From: Nathanael Stock
Sent: 13 May 2022 00:43
To: DC Support
Subject: FW: 21/02893/REM - OS Parcel 4300 North Of Shortlands And South Of High Rock, Hook Norton Road, Sibford Ferris

From: Tim Screen <Tim.Screen@Cherwell-DC.gov.uk>
Sent: 07 March 2022 14:44
To: Nathanael Stock <Nathanael.Stock@Cherwell-DC.gov.uk>
Subject: 21/02893/REM - OS Parcel 4300 North Of Shortlands And South Of High Rock, Hook Norton Road, Sibford Ferris

The LAP

arc  
Sibford Ferris  
ILLUSTRATIVE LANDSCAPE MASTERPLAN  
CLIENT - Gade Homes  
Dwg No. - A318 LA02 Scale - 1:500@ A1 Date - 02/08/2021

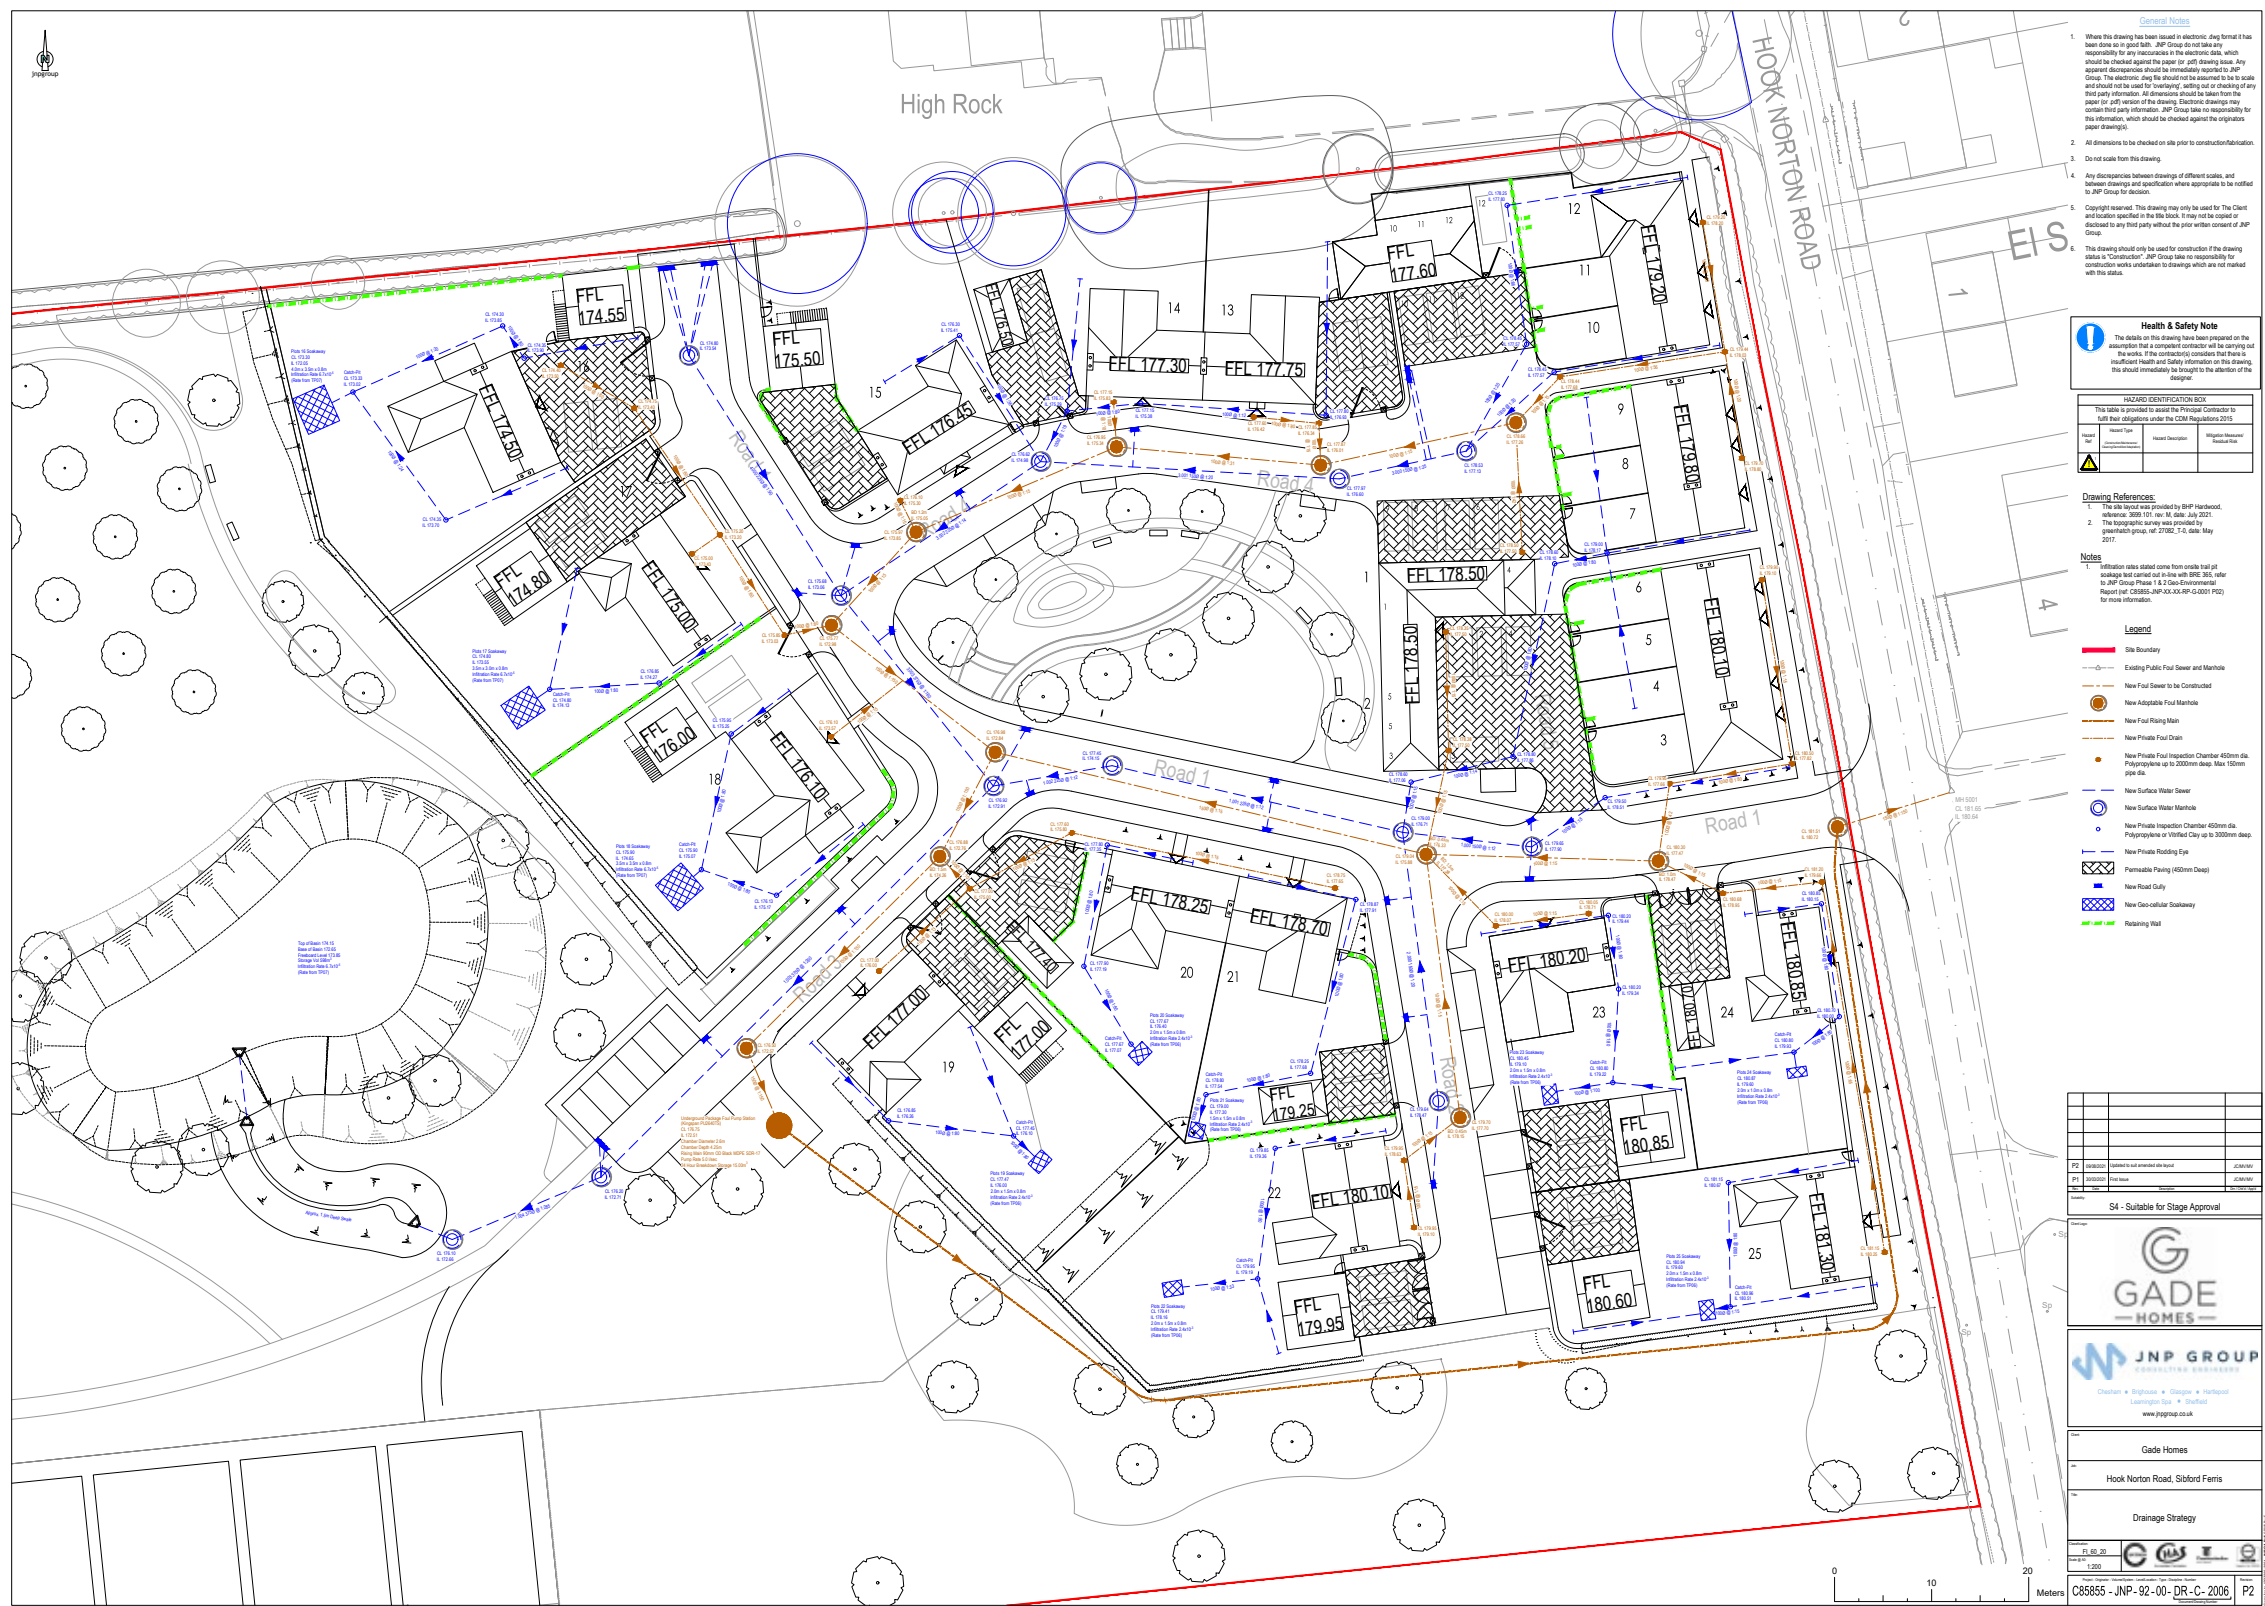
1. Proposals Plan 1 of 3 it is a concern that there are no movement-generating equipment such as a slide and a swing. These items should be included to improve the play experience. The swing to have and bucket seats. The slide to be north-facing to reduce the harmful effect of solar heat on steel, which could be hot enough to burn a child's skin. INCLUDE A NORTH-FACING SLIDE.

5. Details of the play area are required in terms of layout/circulation/fall height, play equipment (with installation), fencing, gates, safer surfaces, seating, signage and litter bins. Compliance with BSEN 1176 is essential. LITTER BIN REQUIRED ALONG WITH A SIGN WITH DEVELOPER'S CONTACT DETAILS. 'NO DOG' CONCRETE SLABS TO BE SET IN PAVING AT THE TWO ENTRANCES.

6. Construction details of the safer surfacing, paths and edging details: timber edging, hoggin and gravel are inappropriate and will not be permitted because of safety and maintenance issues. CONFIRM THE CONSTRUCTION OF THE RUBBER MULCH SURFACE AND THE CONTAINING EDGES. THE ARRANGEMENT DRAWING DOES NOT SHOW THIS INFORMATION. THE PROPOSED BOUND GRAVEL PATH NEEDS TO BE EXPLAINED. ANY LOOSE GRAVEL NEAR A PLAY AREA WILL CAUSE CHILDREN TO SLIP AND HURT THEMSELVES.

2. There is no secured maintenance access for the restricted ecological area. This area is ecological importance and therefore should be included in an overall LEMP report for the green space. THE TYPE OF SECURITY FENCING FOR THE ECOLOGICAL AREA SHOULD BE CLARIFIED BETWEEN THE PUMPING STATION AND THE SOUTHERN BOUNDARY.

7. The relevant British Standards should be clarified within the planting specification and aftercare proposals provided - refer to crib sheet enclosed. I await the Management Plan to accompany the landscape proposals. IRRIGATION METHODS SHOULD COMPLY WITH BS8545:2014 11.3 IRRIGATION.

8. The open space around the balancing pond should have British native shrubs and trees to provide a food source for British wildlife, hence replace *Betula nigra* with *B. pendula*.

A dog bin should be installed near the pedestrian entrance to the car park and indicated on the general arrangement and landscape proposals.
